6 December 2021

Thank you giving Ku-ring-gai Council the opportunity to provide a submission for Application No. SSD-17424905 (Pymble Ladies Collage – Grey house Precinct) at 20 Avon Road, Pymble. Council's comments in relation to the proposal are as follows:

SHADOW DIAGRAMS -
SHEET 1

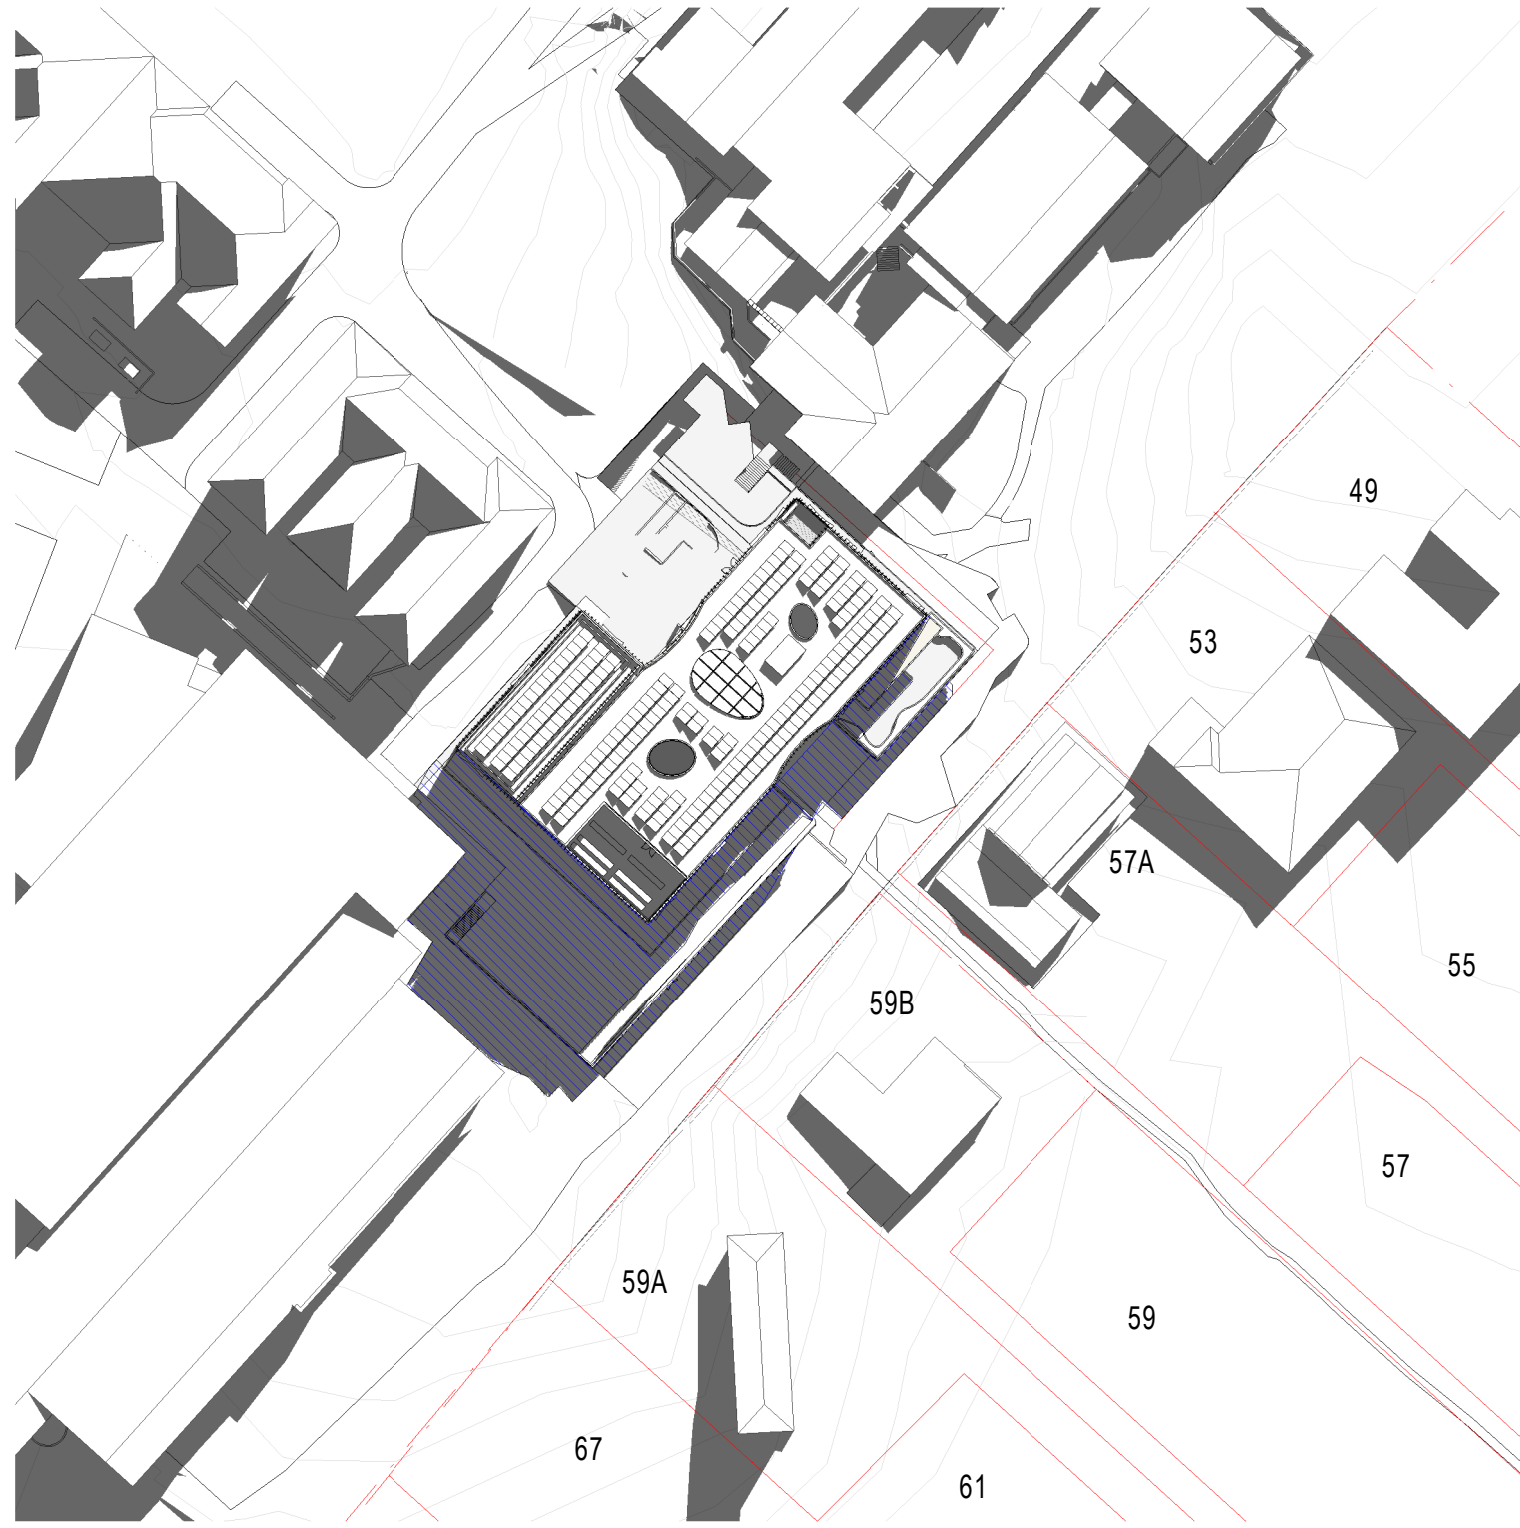
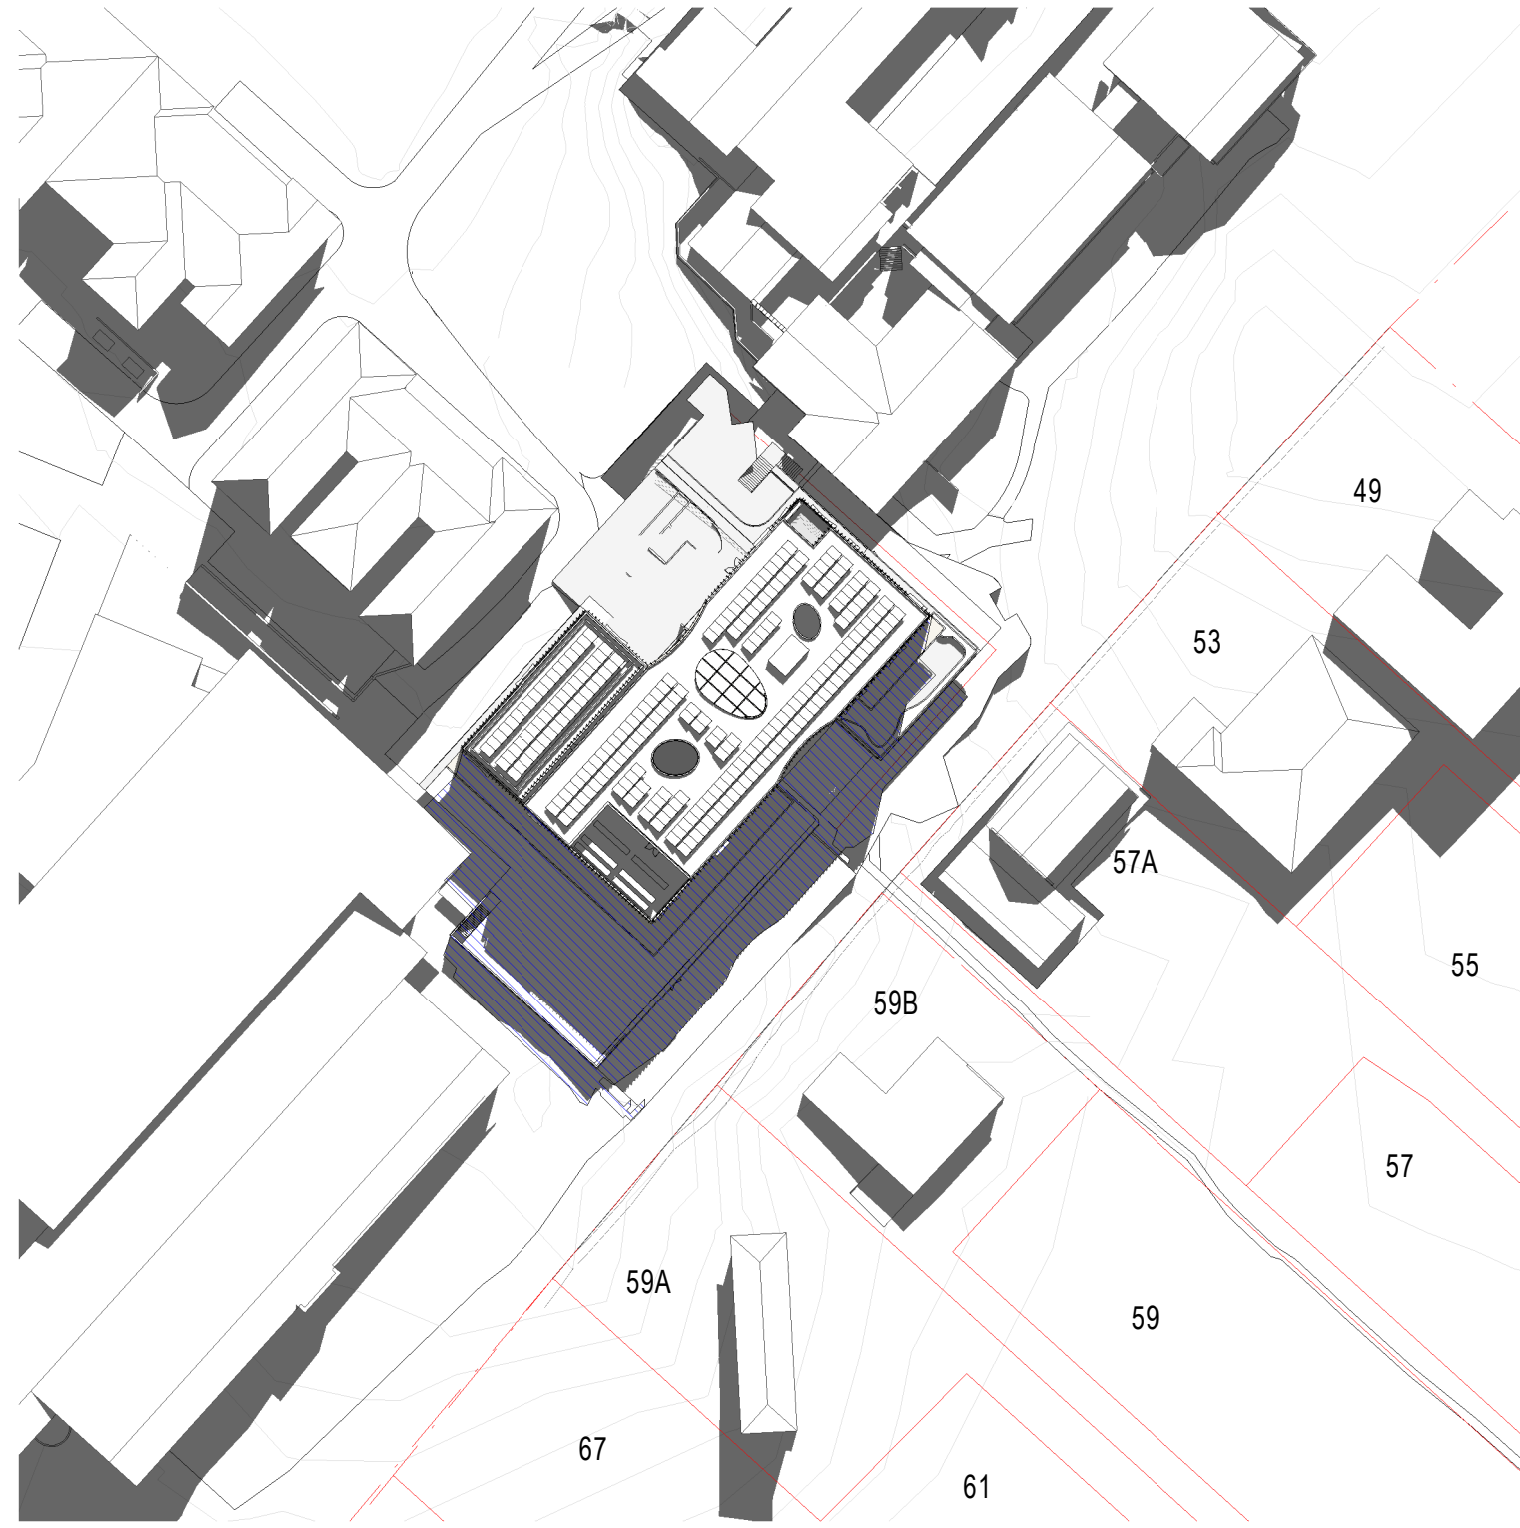
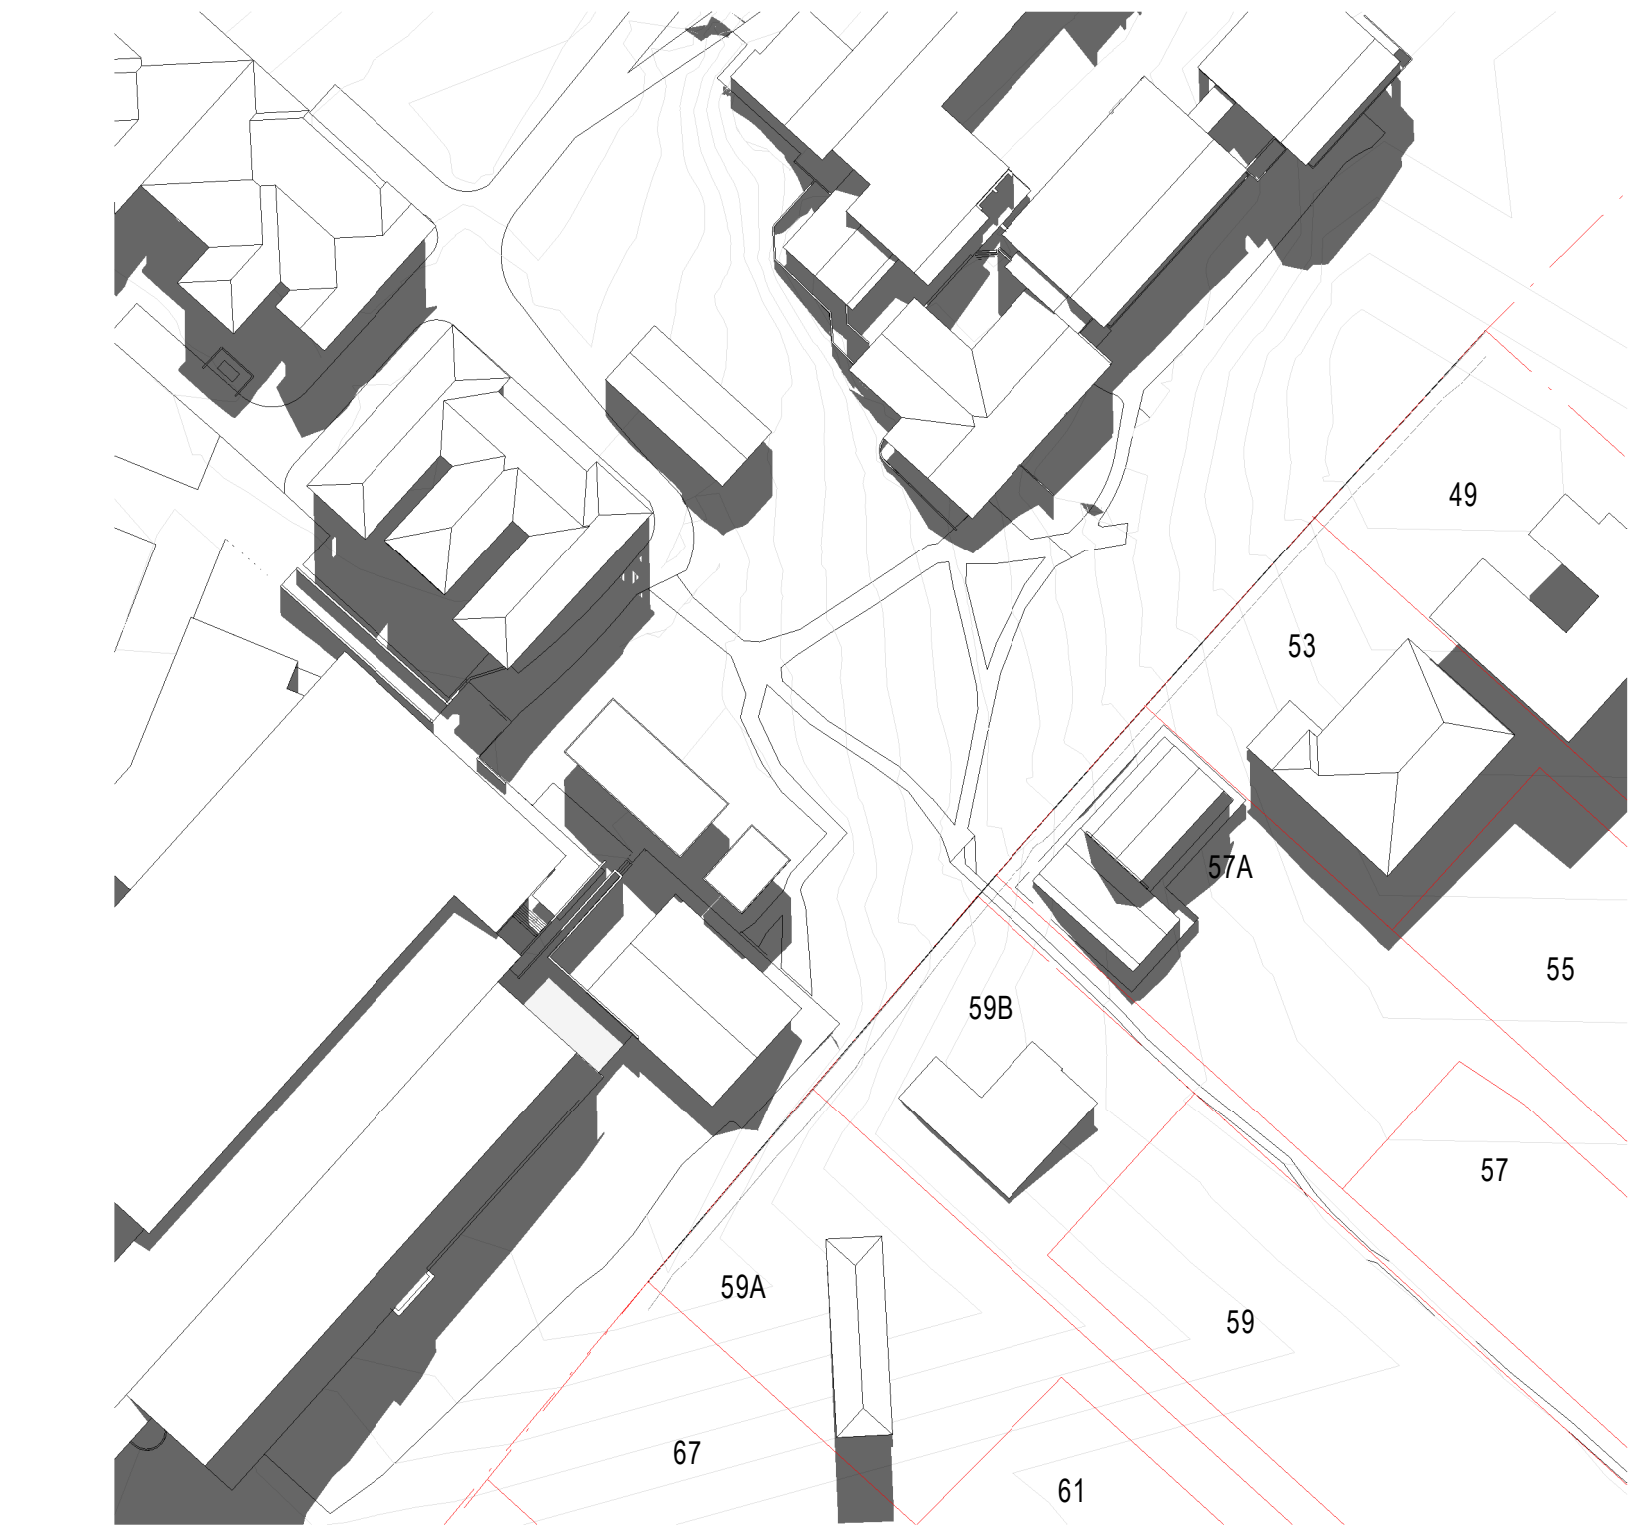
Page 85 of the EIS contains the following statement:

*As shown in the Shadow Diagrams (**Appendix 8**), no additional overshadowing of the adjoining properties would be created prior to 12pm midday on the Winter solstice. As such, the proposal would effectively maintain three (3) hours of solar access between 9am-12pm on the Winter solstice, thereby complying with KDCP.*

This statement is flawed for the following reasons:

As the proposal predominantly impacts upon windows on the rear (north-western) elevations and rear private open space of adjacent dwelling houses the impacts upon these dwelling houses cannot be properly assessed using the plan view shadow diagrams that have been provided. A more detailed analysis of overshadowing impacts is required. Having regard to the scale of the proposal and the disparity in height between the proposed building and adjacent dwelling house it would be reasonable for the applicant to adopt the requirements of the Land and Environment Court Class 1 Practice Note which are set out below:

- *be based on true north;*
- *indicate the location and nature of existing and/or proposed fencing, with the shadows projected;*
- *indicate horizontal and vertical impact, including any impact from any substantial wall;*
- *provide a table of compliance and non-compliance with known criteria (such as a development control plan, a State environmental planning policy or Australian Model Code for Residential Development (AMCORD)); and*
- *make appropriate allowance for the topography.*
